**Glades Estate Residential Subdivision MOD 5 (MP06_0143-Mod-5)
Request for additional information**

I refer to the proposed modification to the project approval at Glades Estate (MP06_0143-Mod-5). After careful consideration, the Department is requesting that you provide the following:

'Subdivision Staging and Staging of Open Space Dedication to Council', Plan No. 110719-02-SK013 dated 02/03/22

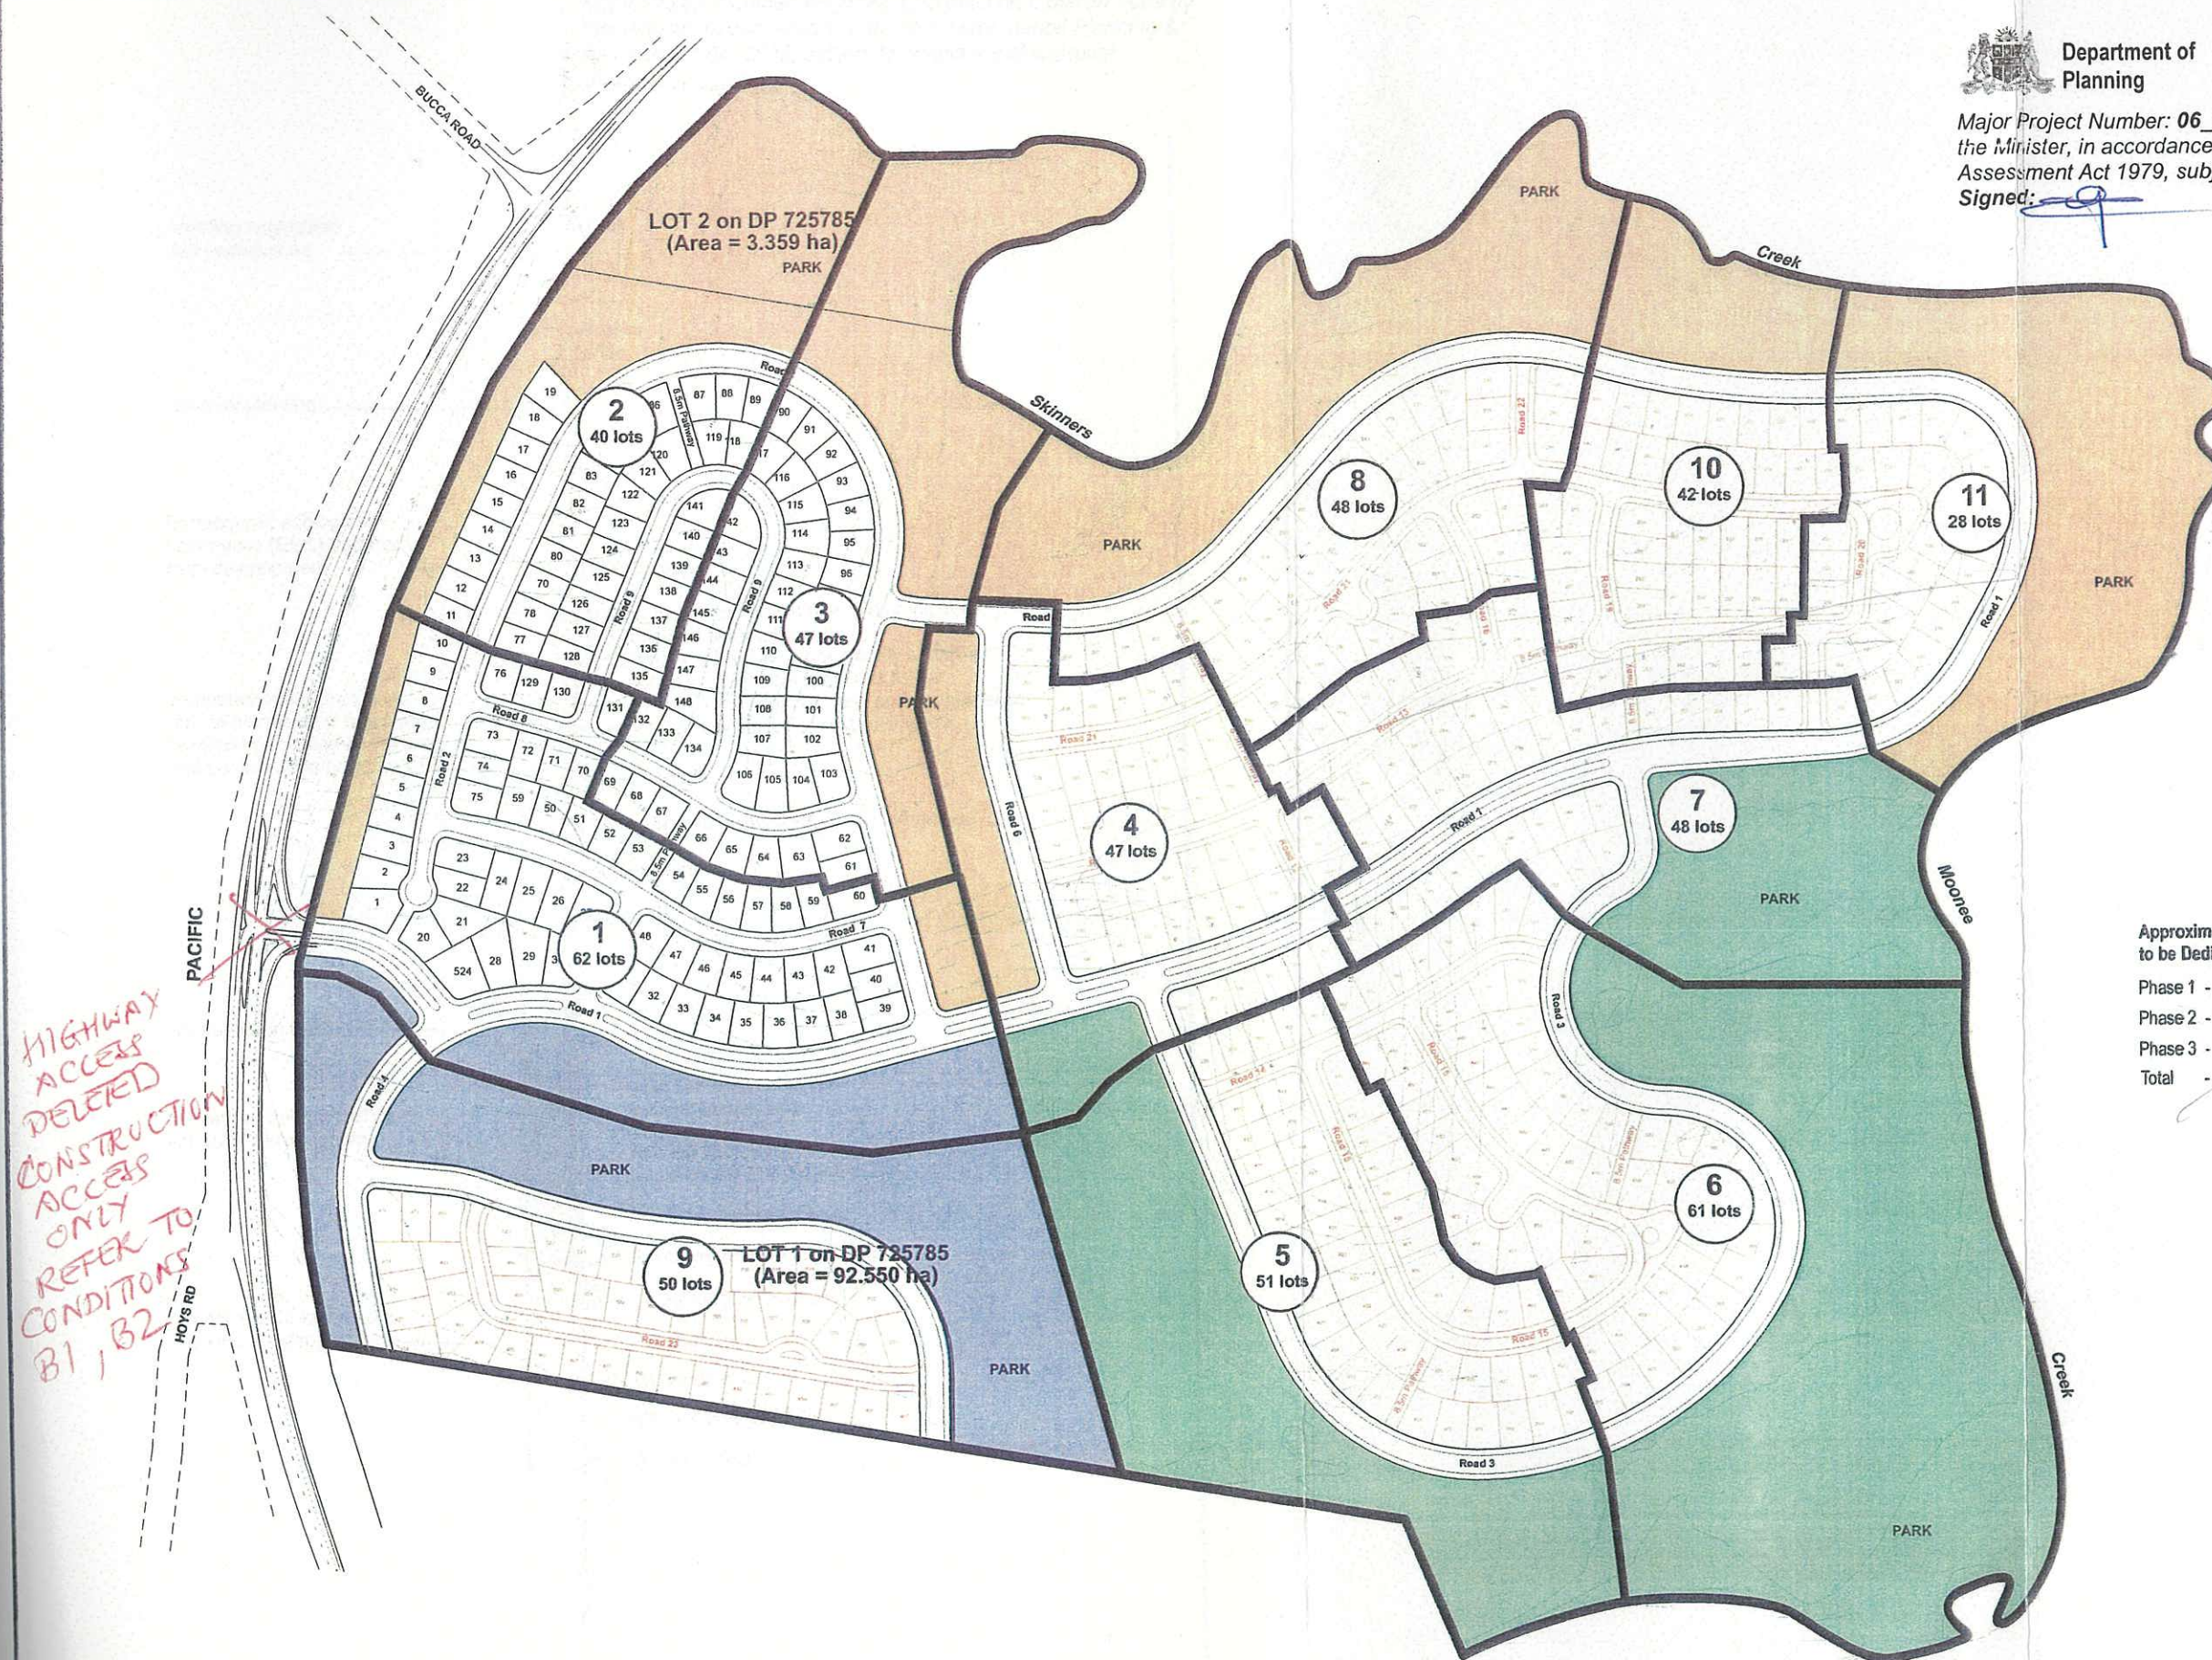
- amend the staging to allow for the central wildlife corridor (small isolated area of proposed Phase 3) to be incorporated into Phase 1 or Phase 2, to enable the vegetation management to coincide with adjacent lands
- consider revising the staging so that Stages 1 to 3 have access to open space before Stage 9 (one of the last few stages) is completed
- a comparison of the approved and proposed number of lots compared to area of open space in each stage
- confirmation that the proposed changes to staging would not affect the required APZs and drainage basins
- an updated landscape staging plan.
